PLANNING CONSULTATION RESPONSE

Application No	2026/0428
Proposal	Erection of a single storey portakabin modular building providing nursery facilities.
Address	Brierley Church Of England Primary School, Beech Close, Brierley, Barnsley, S72 9EJ
Date of Consultation Reply	24/06/2026
Consultee	Katie Lawrence, Planning ecologist

Appendix 3: Habitat Survey Plan

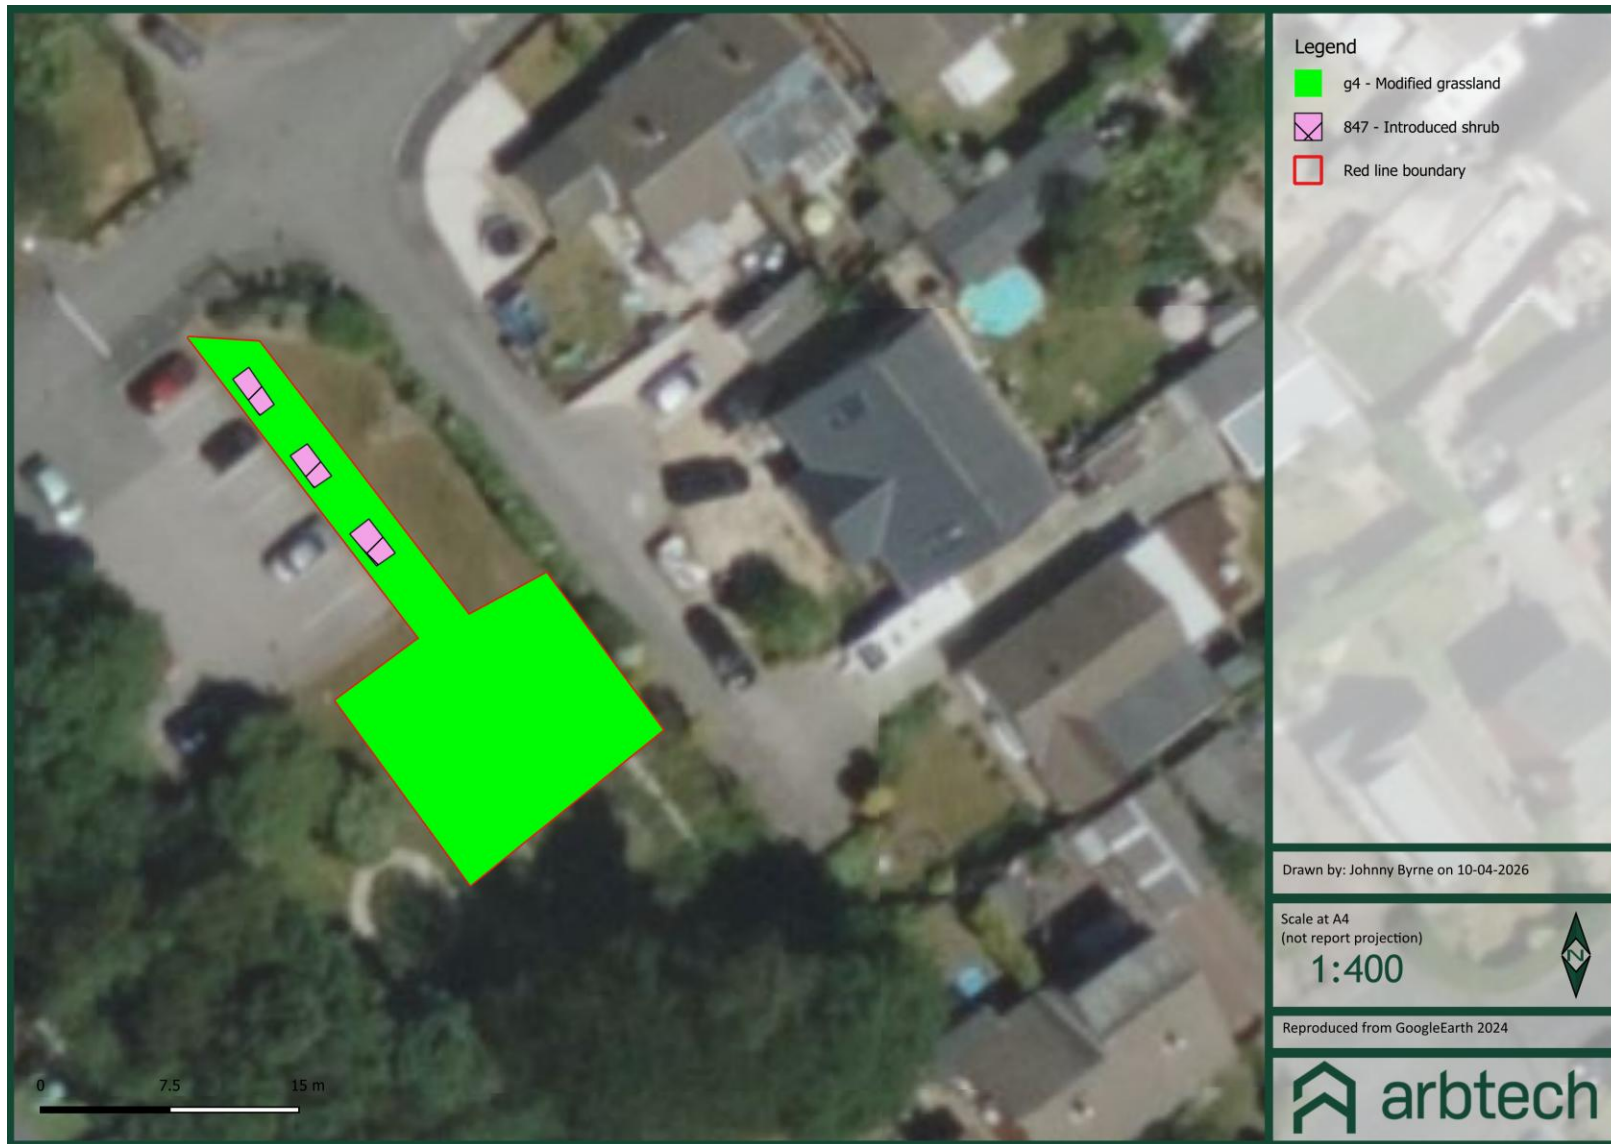
- The PEA does not map introduced shrubs to the east of the site in association with fencing along Beech Close. Proposed hardstanding in association with the proposed portakabin abuts the eastern boundary and therefore may impact this habitat. Consideration should be given to this within the PEA and BNG report (again the area of shrubs is not mapped) including the potential impact to nesting birds and the requirement for precautionary works in relation to such species.

- The shrubby area that occurs to the eastern boundary of the site has not been mapped and included within the metric. As discussed above, consideration should be given to whether the proposals will impact this area.
- The metric should be amended to remove reference to a ditch within the watercourse baseline tab.
- The proposals intend to retain the existing pond. As is stated within the Statutory Biodiversity Metric User Guide, retained habitats can contribute to post-development biodiversity units; however, they may still require ongoing management to maintain their
